6 May, 2013

**RE: PART 3A PROJECT APPLICATION FOR  
PROPOSED MIXED USE DEVELOPMENT, EASTLAKES**

1. As requested, we have reviewed the traffic matters raised by Council's traffic consultant, McLaren Traffic Engineering (MTE) in its letter dated 9 April 2013. These matters can be summarised as follows:

DRAWING TITLE  
SOUTH SITE NORTH RAMP SECTION

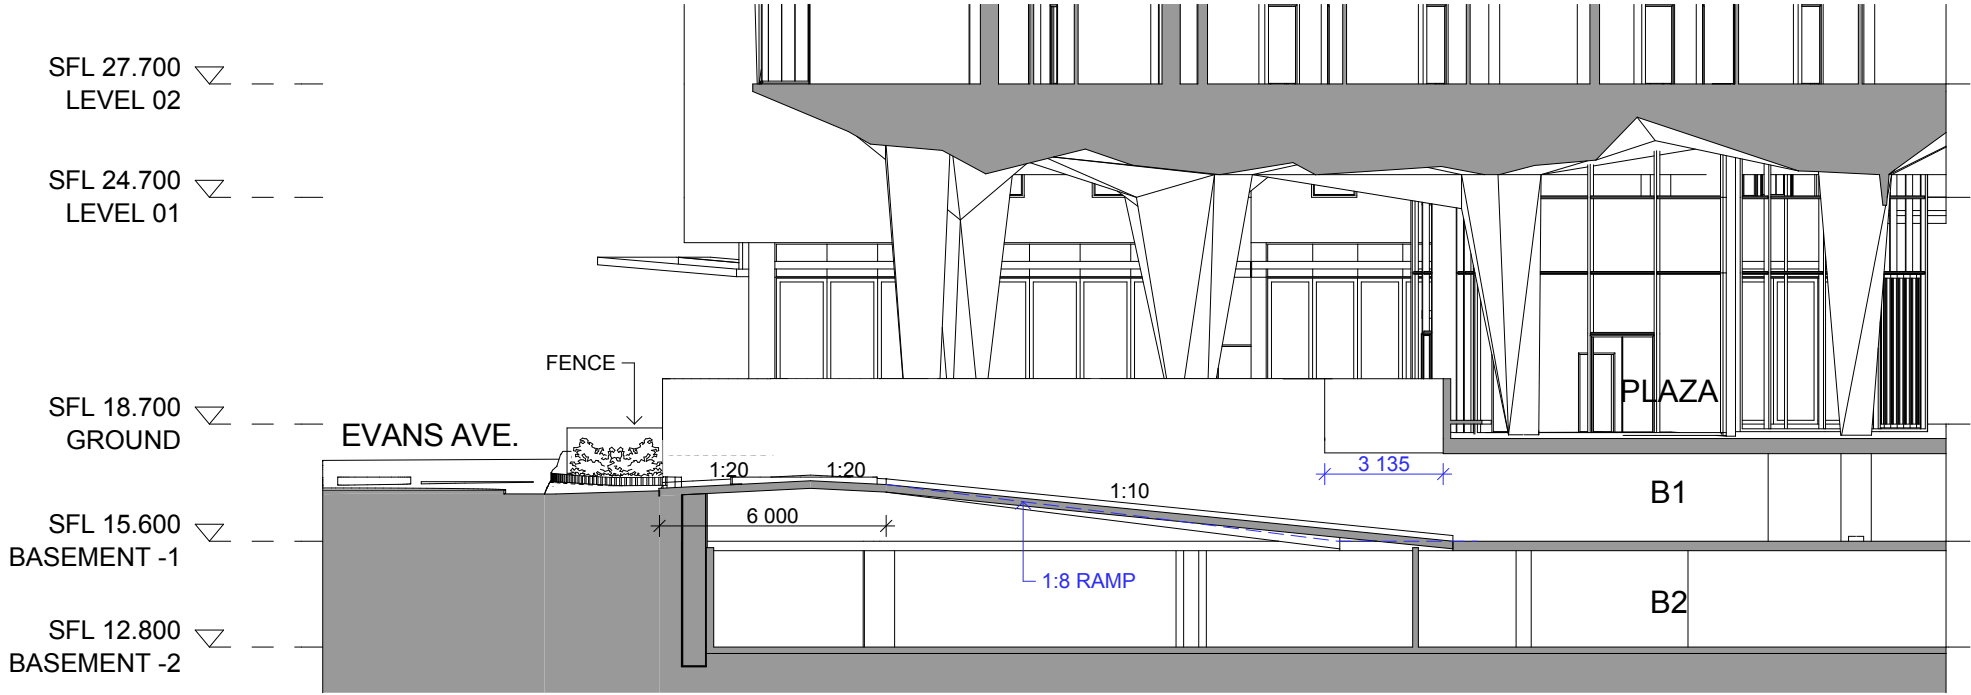
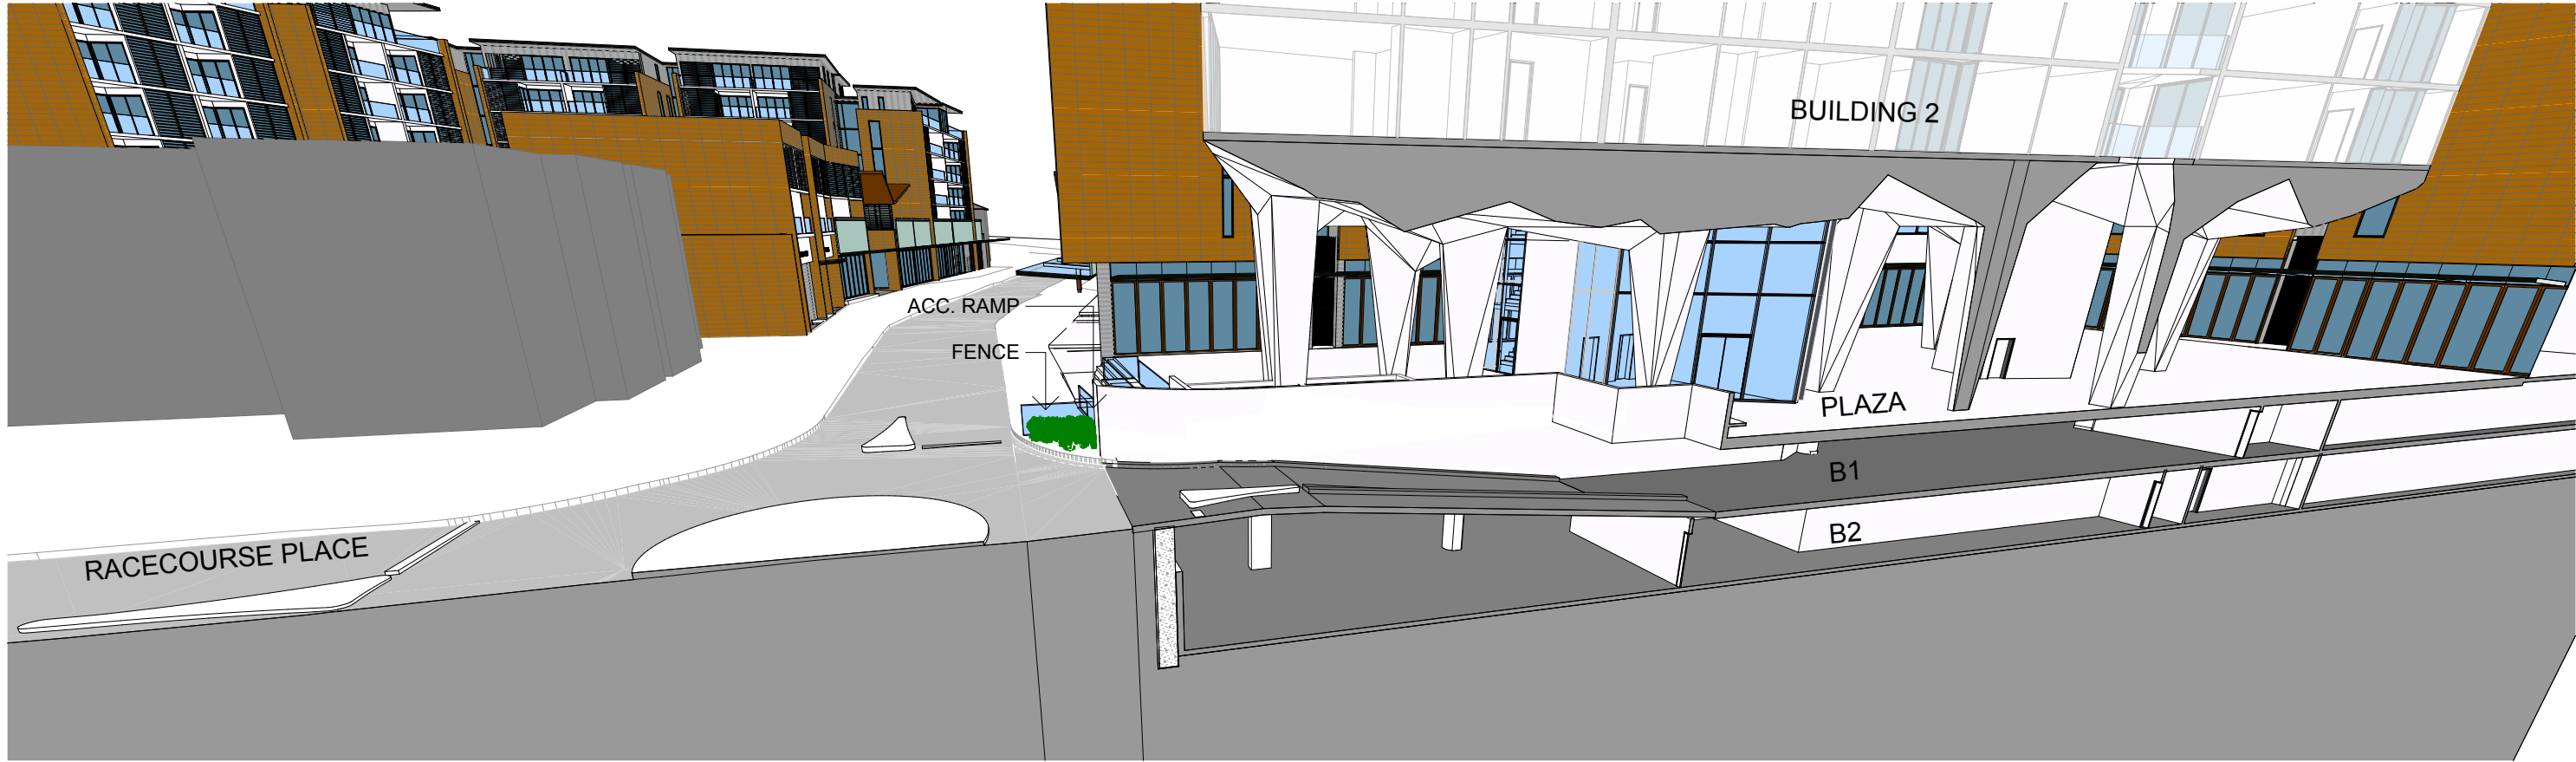
15. MTE has requested clarification that the ramps grades and sight lines at the Evans Avenue Access from the southern car park are appropriate.
16. Plans prepared by Rice Daubney and VDM Consulting show the reconfigured design of the access to/from the southern car park to the roundabout at the intersection of Evans Avenue and Racecourse Place. The key points are:

- the stop line for egress from the car park is set back from the movement of traffic through the roundabout (lines up with end of median island);
  - the elevated podium does not block sight lines for vehicles exiting the car park with sight lines available to the eastern and western approaches to the roundabout;

- the pedestrian fence located either side of the access will be constructed so that sight lines will not be obstructed; and
  - grades are 1:20 for the area in which a car would stop before exiting the car park with 2 metre 1:8 transition before a 1:10 ramp to accommodate queuing of vehicles exiting the site.
